KITTITAS COUNTY DEPARTMENT OF PUBLIC WORKS

MEMORANDUM

TO: Kaycee Hathaway, Community Development Services
FROM: Kelly Bacon, Engineer Technician I *KB*
DATE: January 15, 2016
SUBJECT: Whitaker BL-15-00017

CRUSE & ASSOCIATES
PROFESSIONAL LAND SURVEYORS
217 East Fourth Street P.O. Box 959
Ellensburg, WA 98926 (509) 962-8242
WHITAKER PROPERTY

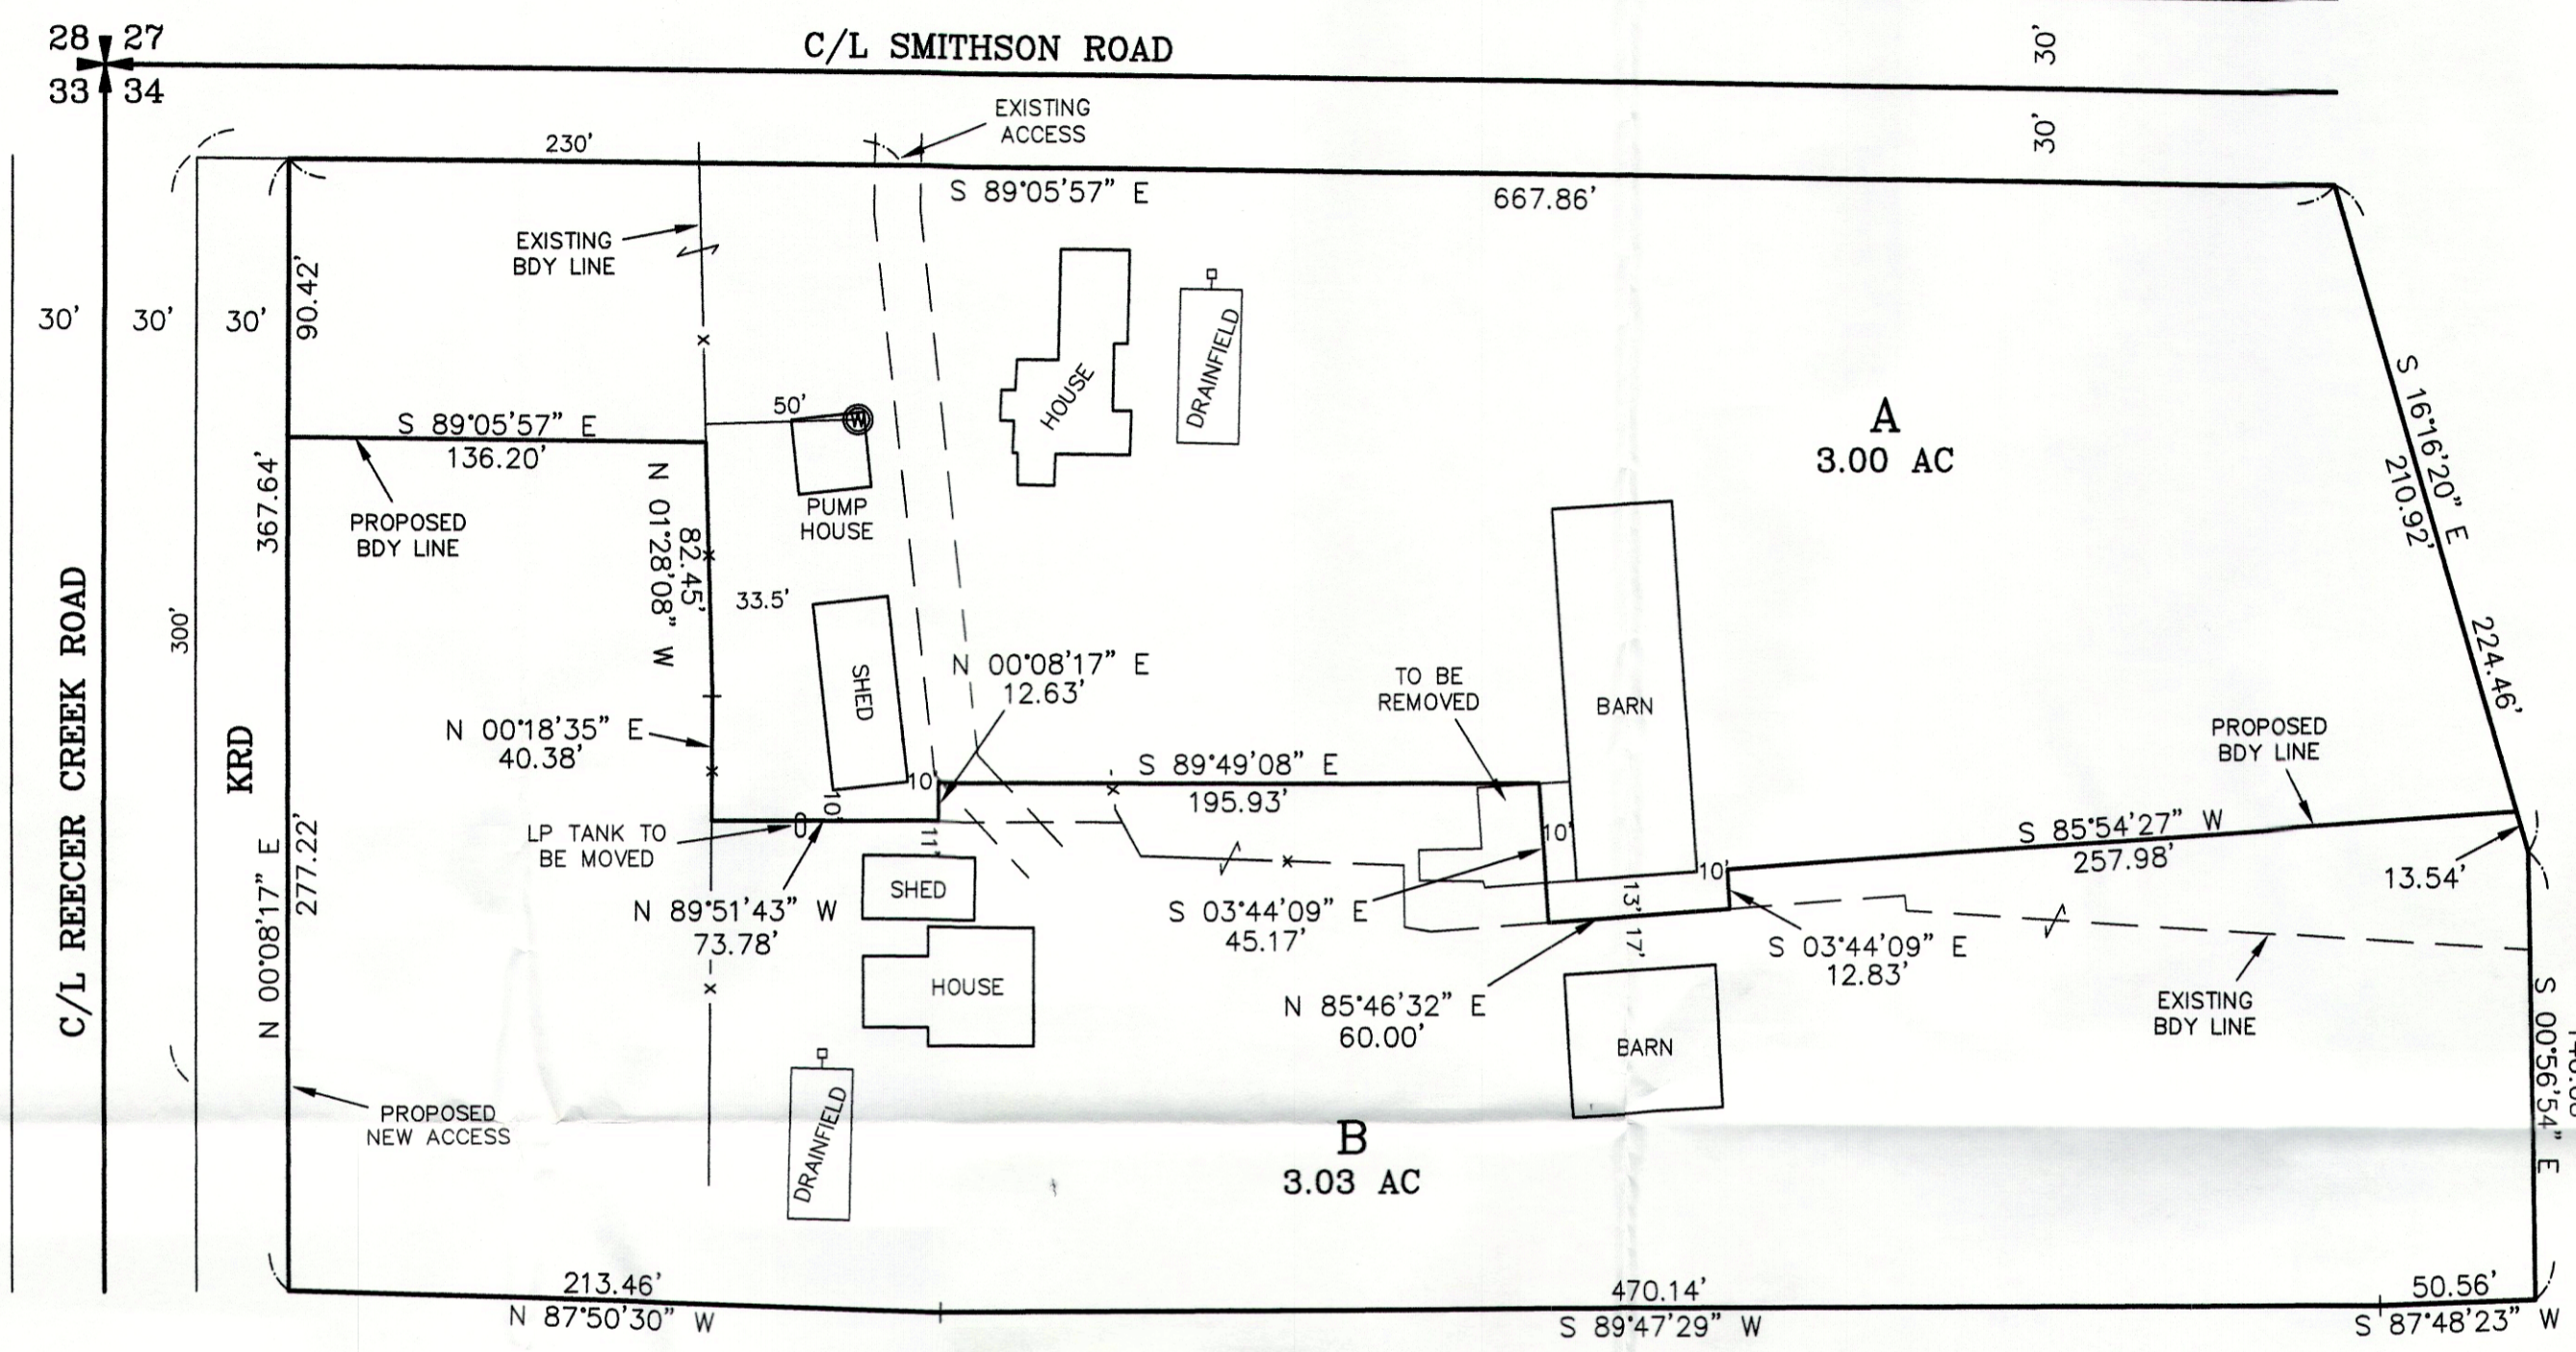
1. A revised legal description that describes the final configuration of the subject property shall be required.
